WELWYN HATFIELD COUNCIL – DEVELOPMENT CONTROL
DELEGATED REPORT

APPLICATION No:	S6/2008/1210/FP
------------------------	------------------------

The proposal is for a single storey rear extension which is 4.06m deep and 5.39m wide with an eaves height of approximately 2.6m. The proposal has a lean-to style pitched roof with materials to match the existing. The extension is to provide a new living area.

Drawing Title
**Plans, Site Plan & Elevations
as Proposed**

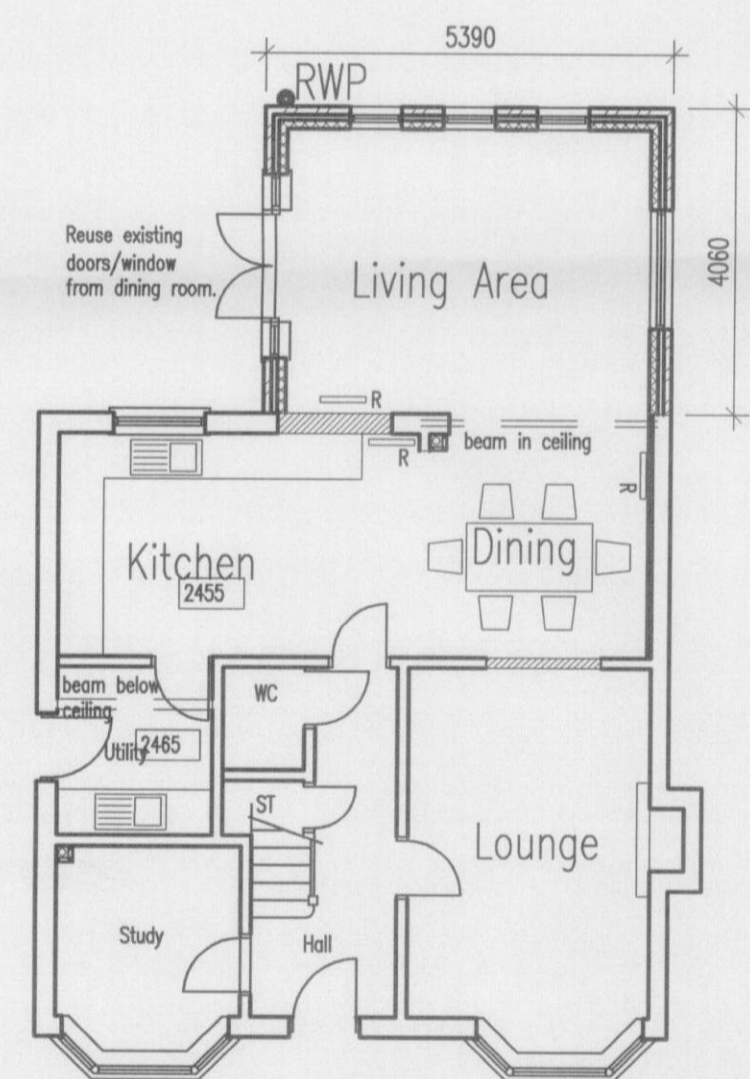
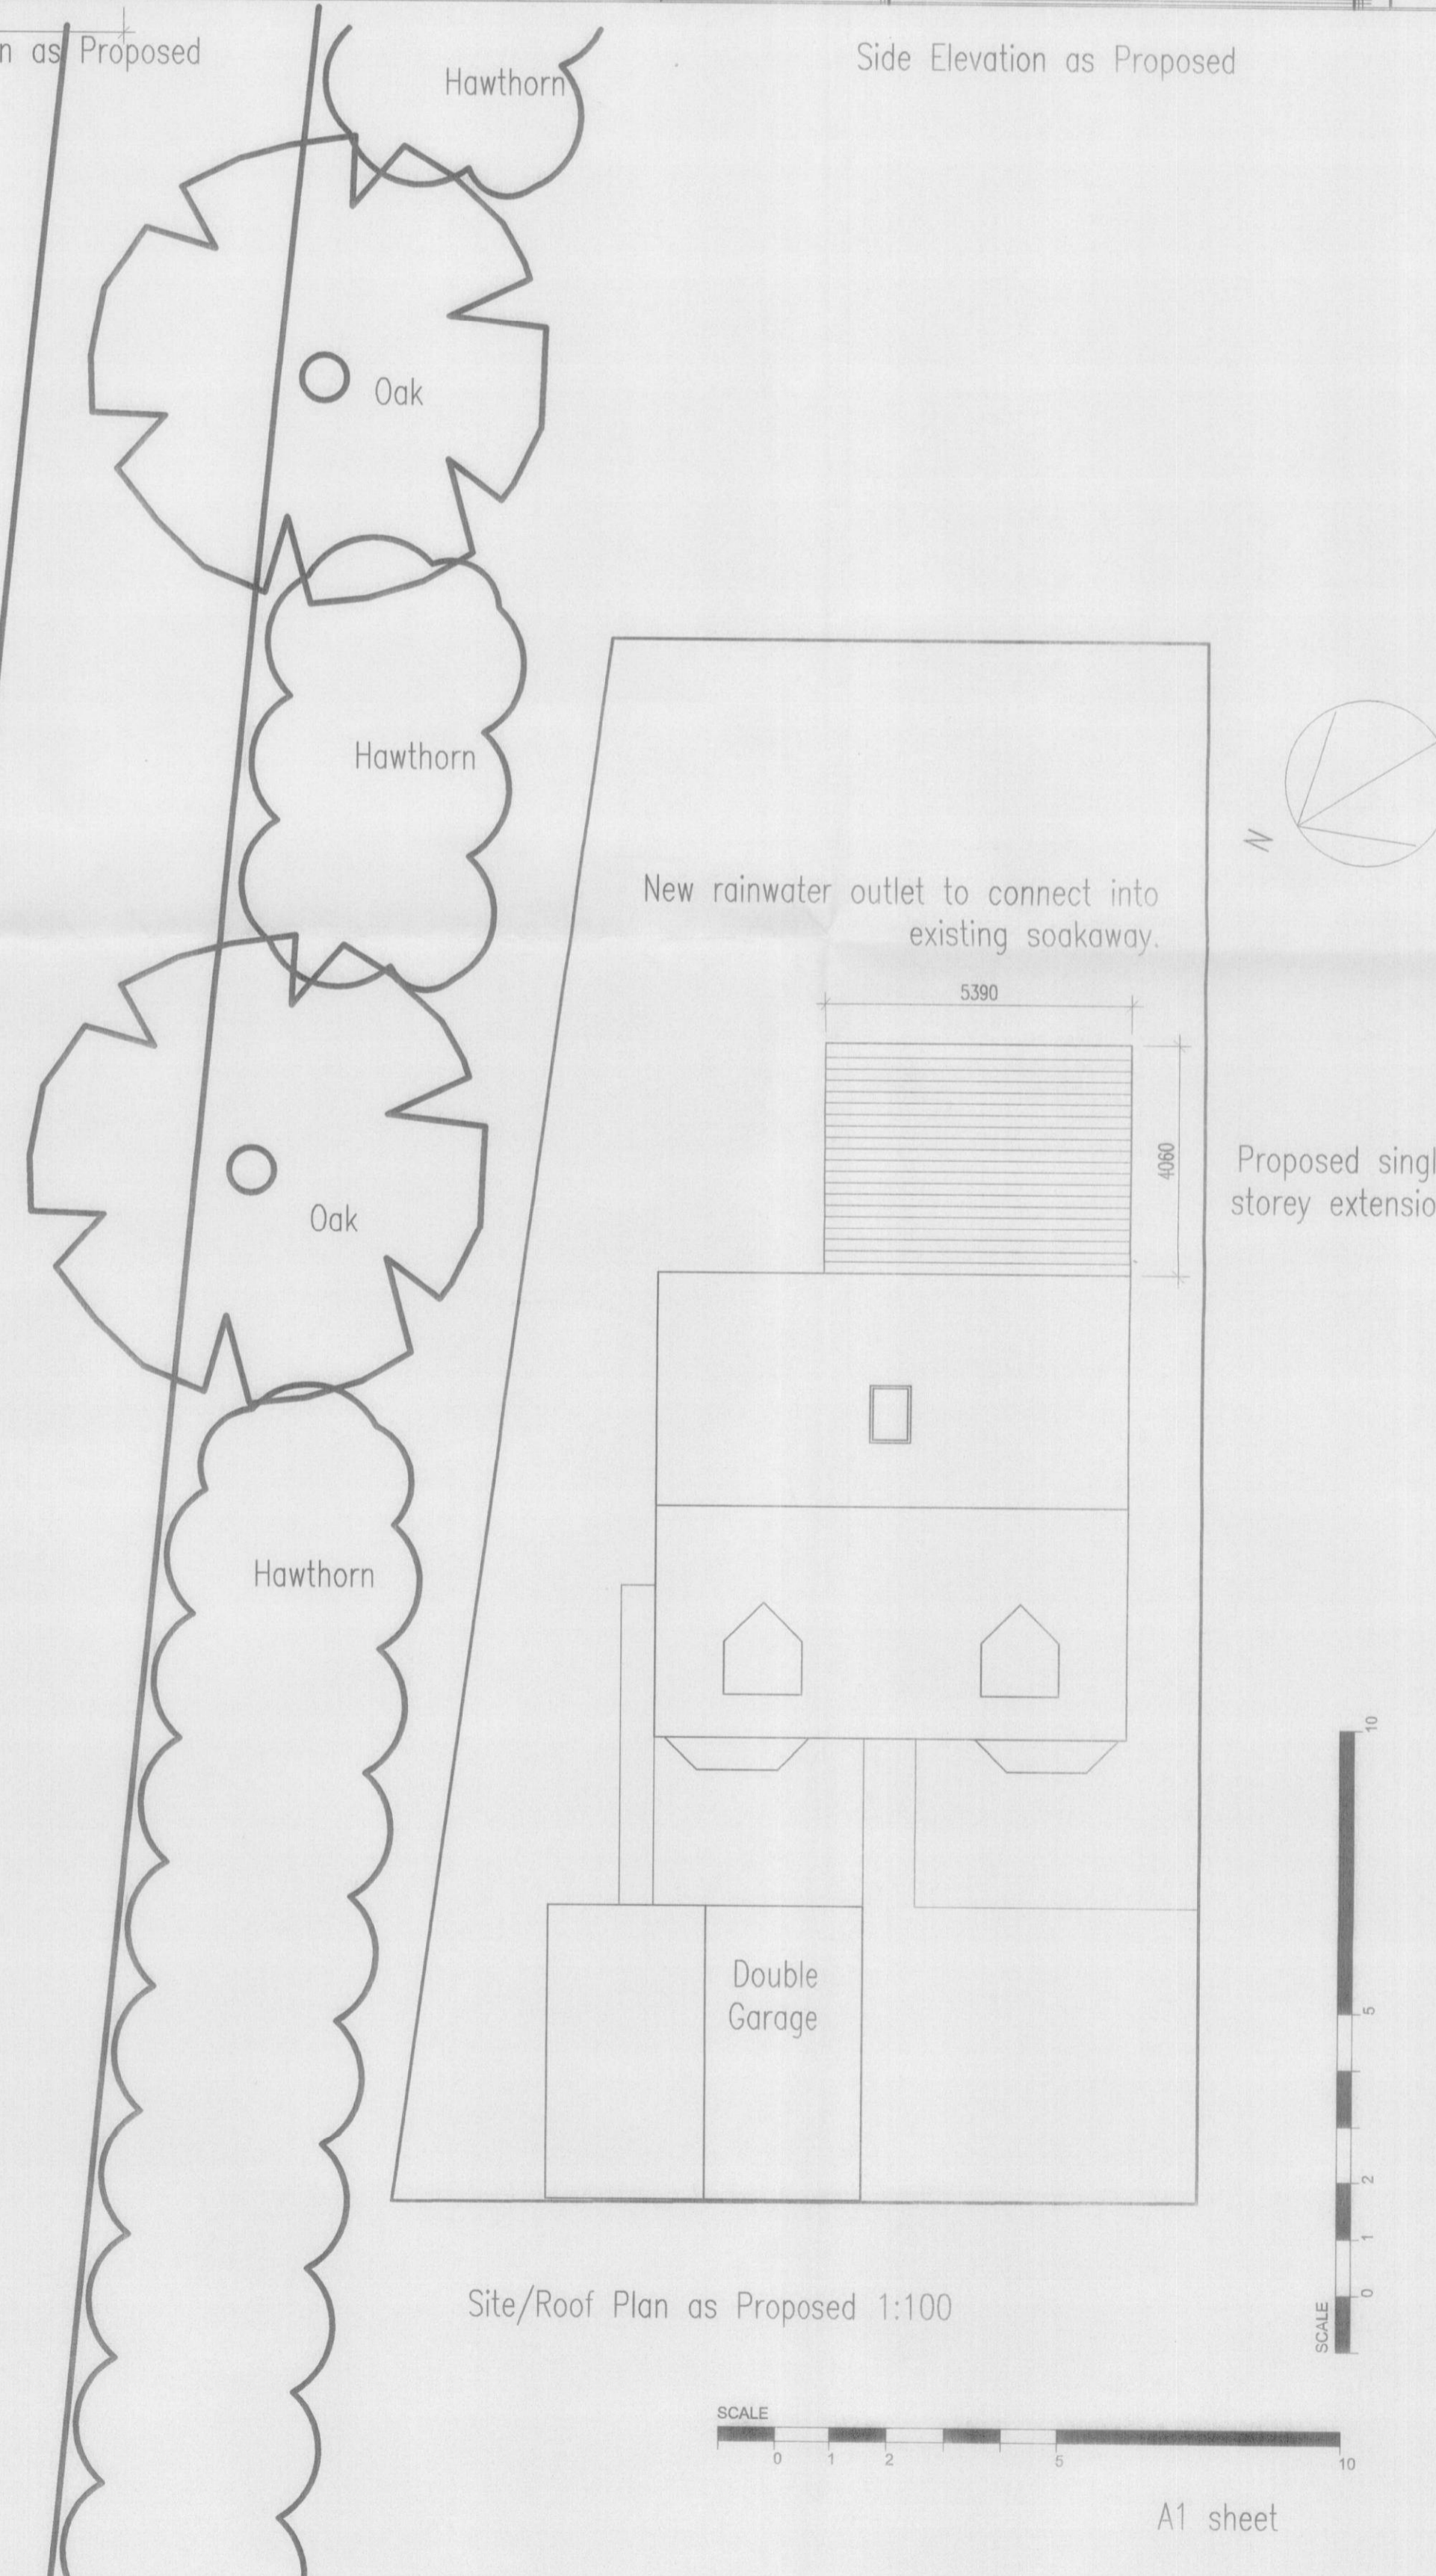
The proposal does have a flank wall window which looks in the direction of No.40, which appears to be under 1.7m above finished floor level. Although in principle a small window at a higher level in this location would be acceptable to provide some light to the new living area of the extension, the current boundary treatment with No.40 could result in overlooking to this neighbour's rear garden. Furthermore, the close proximity of this window to the boundary could result in noise disturbance if the window is open and so it would be reasonable to limit this window to being obscure glazed and non-opening by imposing a suitably worded planning condition.

In regards to the visual impact, the proposed depth of approximately 4m is considered acceptable in this location taking into account the orientation of the site and the location of the neighbour's rear ground floor window and its use for a habitable room as the resultant loss of sunlight/daylight would not be significant. The proposed height and depth of the new flank wall would also not appear either overbearing or dominant when viewed from the rear windows of No.40 or rear terrace area.

1. C.2.1 Standard 3 Year time limit
2. C.13.1: Development in accordance with approved plans/details: PL/03 (1:1250 Site Location Plan) & PL/01 & PL/02 – received and dated 15/07/08.
3. C.5.2 Matching Materials
4. The proposed side window on the new extension shown on approved drawing PL/02 date stamped 15/07/08 adjoining the boundary to No.40 Bluebell Way is to be obscure glazed and non-opening. This window shall be retained in that form thereafter.
